STOKESLEY

ARCHITECTURAL JOINERY CO

Mr J. Hall
The Bay Horse
45 The Green
Hurworth
Darlington
DL2 2AA

26th November 2020

CROSS SECTION THROUGH SLIDING SASH WINDOW.

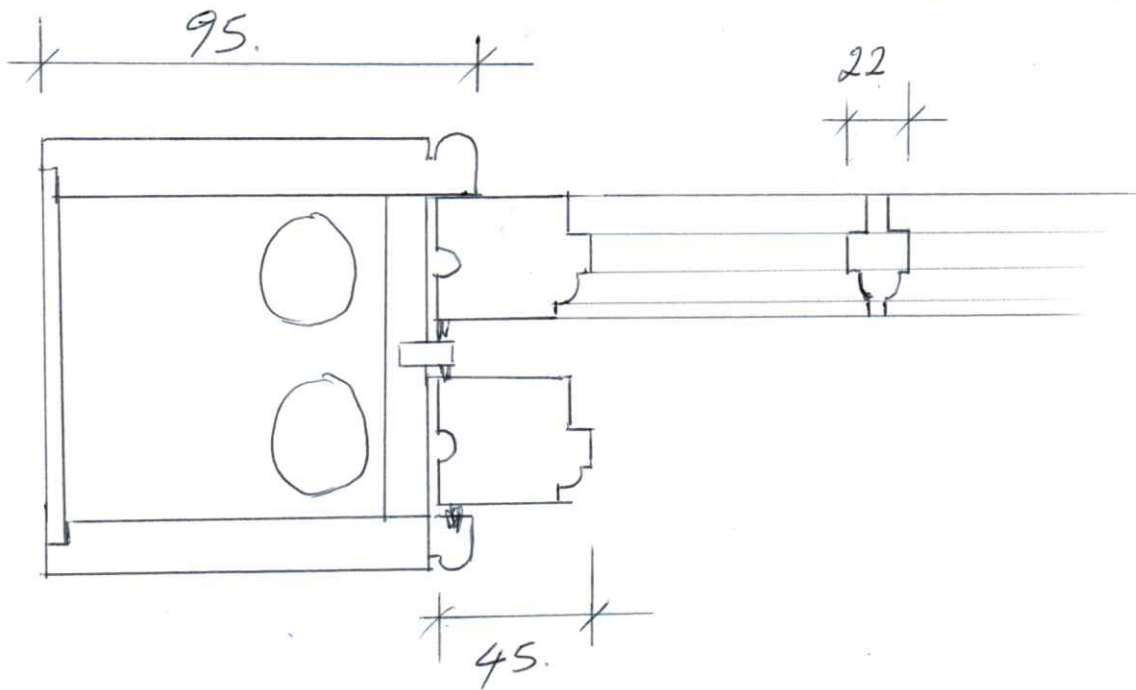
Further to my visit to The Bay Horse regarding the front elevation windows it appears that most of the windows have had recent replacement sashes which have incorrect timber sections and mouldings, none of which are consistent.

The boxes to the windows are mainly rotten and would require removal and replacement to ensure the windows would have reasonable lifespan and sashes would work and seal correctly.

There are however a couple of the windows which do have some of the original sashes in, I would suggest we remove and restore these sashes and any sashes that were replaced would replicate these regarding timber sections and mouldings.

Any new timberwork will be hardwood, preservative treated and fully painted. Draught seals will be incorporated into both new and refurbished windows. Timber sections and mouldings will be replicated off the original windows.
